# ***City of Albuquerque***

March 7, 1996

**RE: GRADING AND DRAINAGE PLAN FOR CANADA RESERVOIR (E24/D1) SUBMITTED  
FOR SITE DEVELOPMENT PLAN FOR BUILDING PERMIT APPROVAL, ENGINEER'S  
STAMP DATED 10/30/95.**

CAÑADA RESERVOIR GRADING & DRAINAGE PLAN

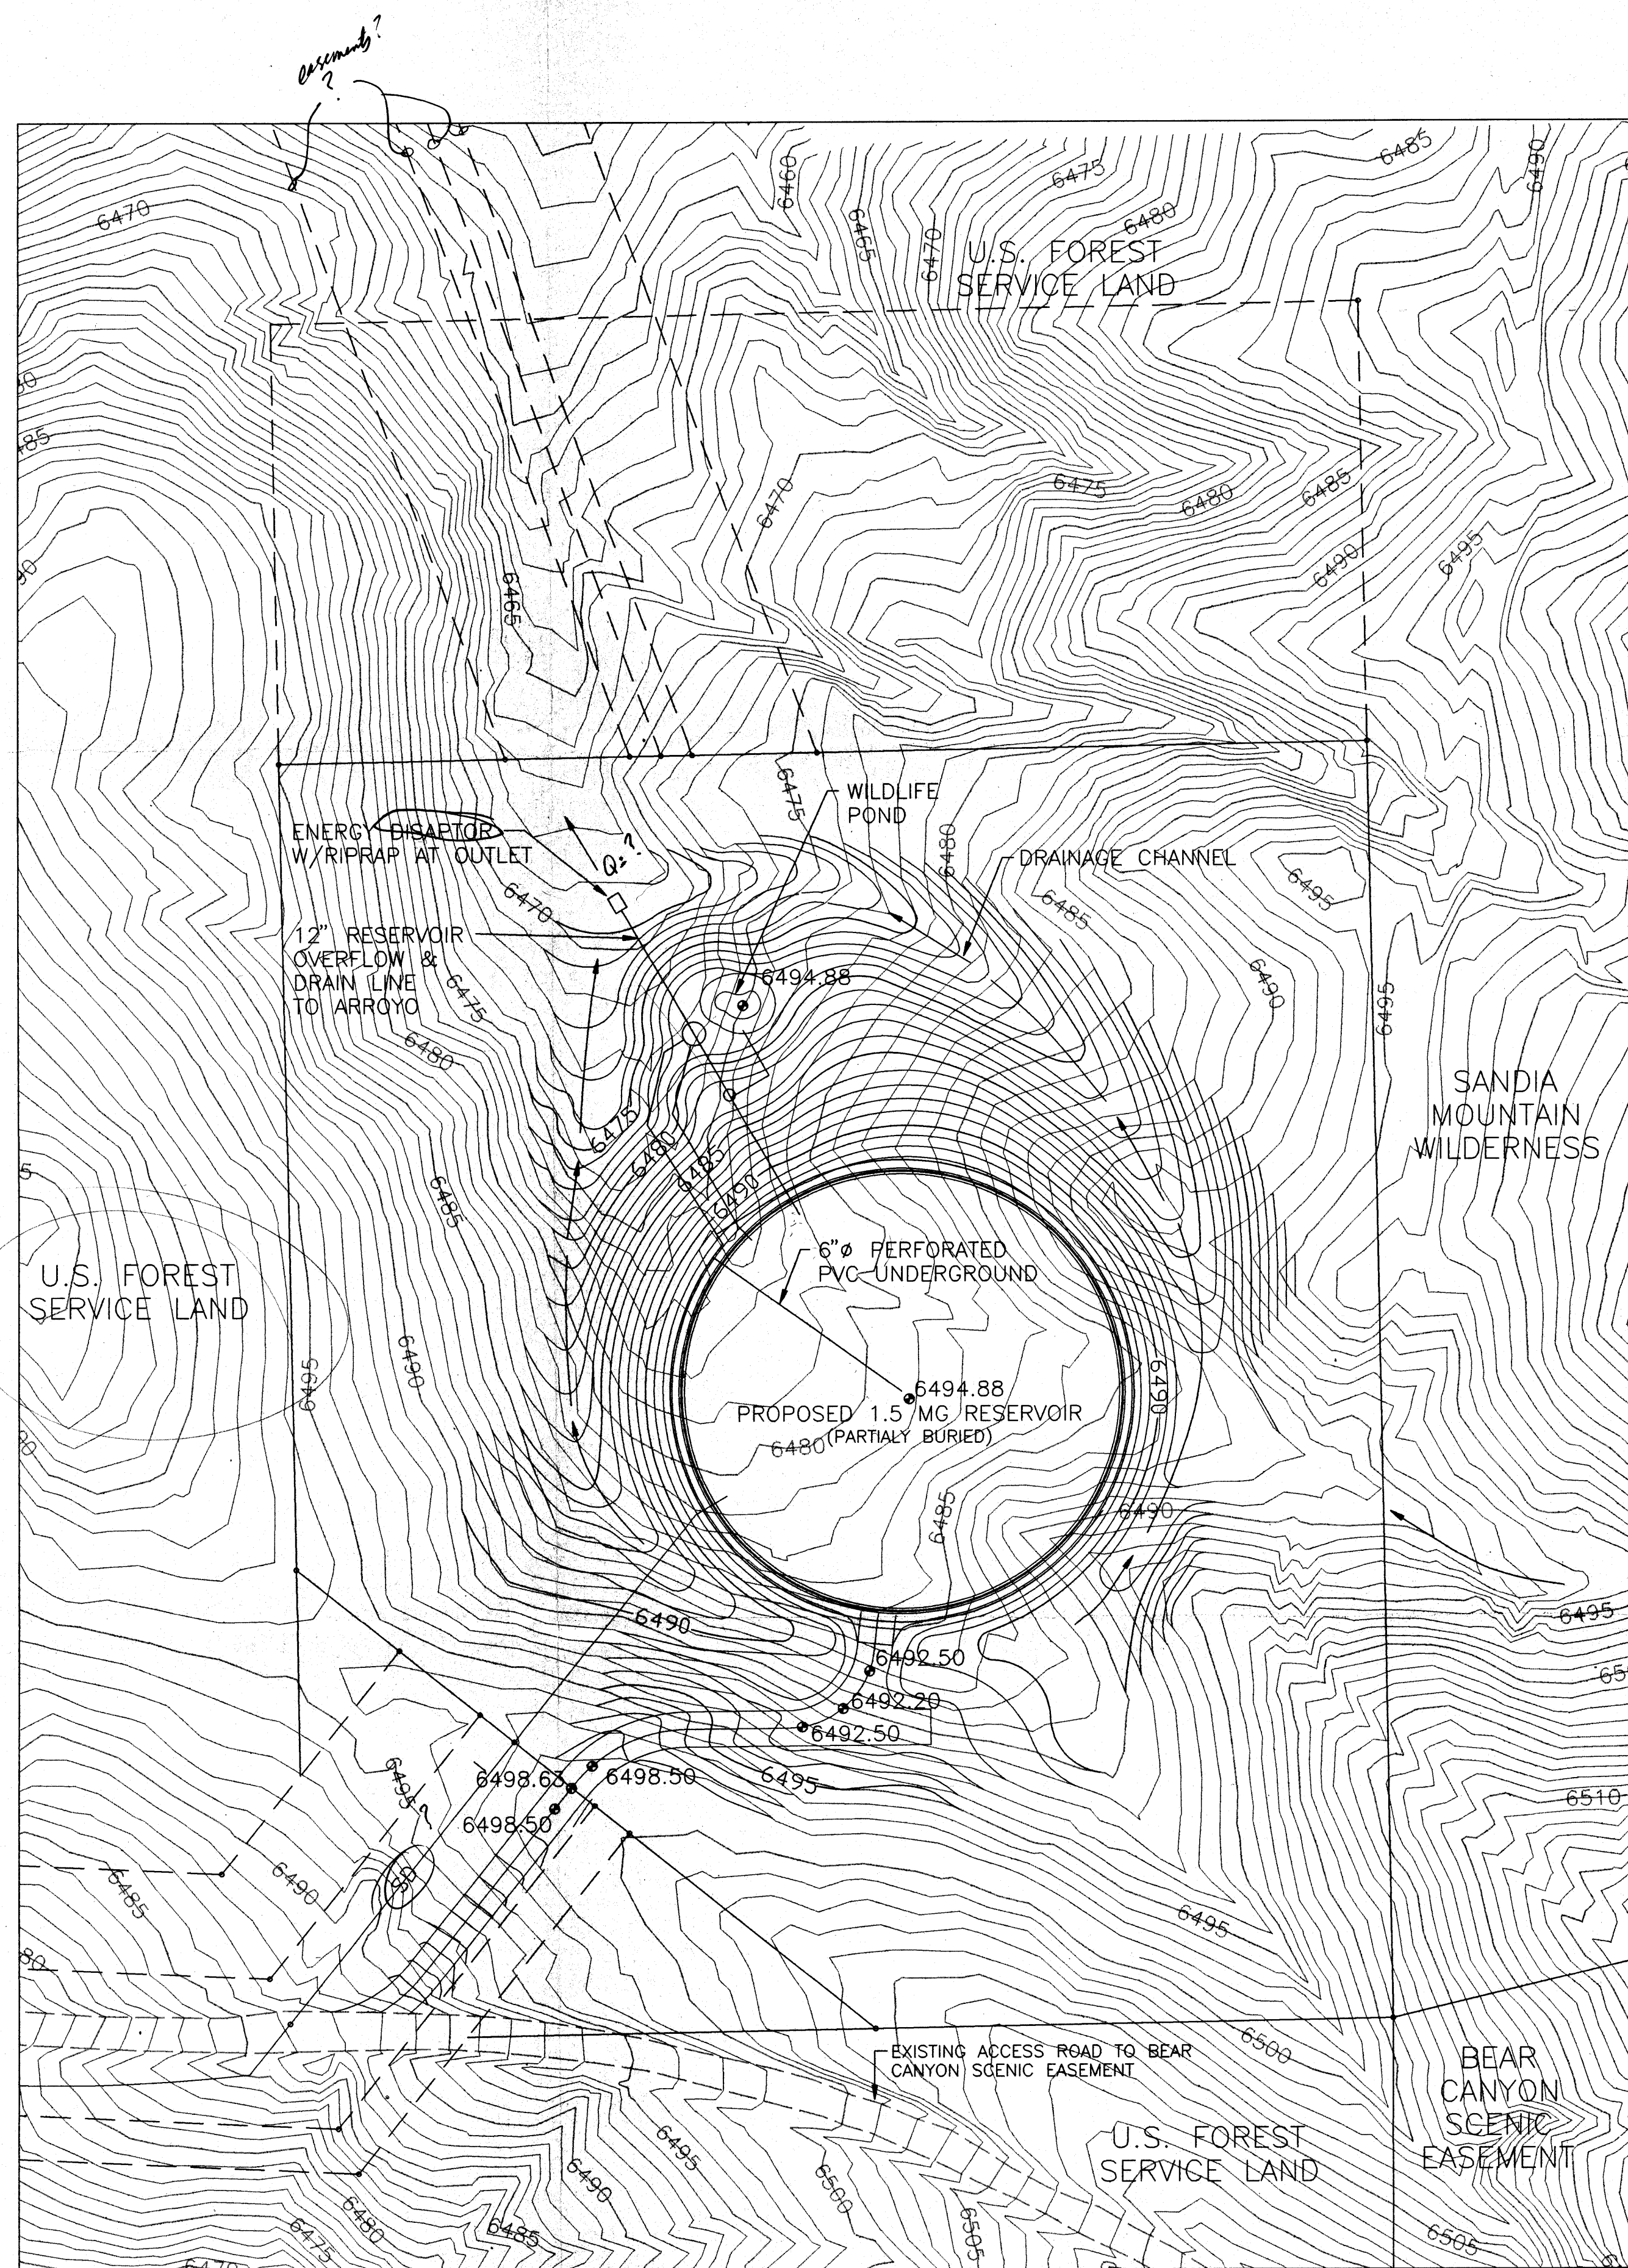
This approved plan shows a temporary construction stockpile area adjacent to the proposed tank. It appears that this stockpile area should be reshaped or moved outside of the flowpath of the proposed drainage channel. This is just a suggestion since this is to be a temporary condition.
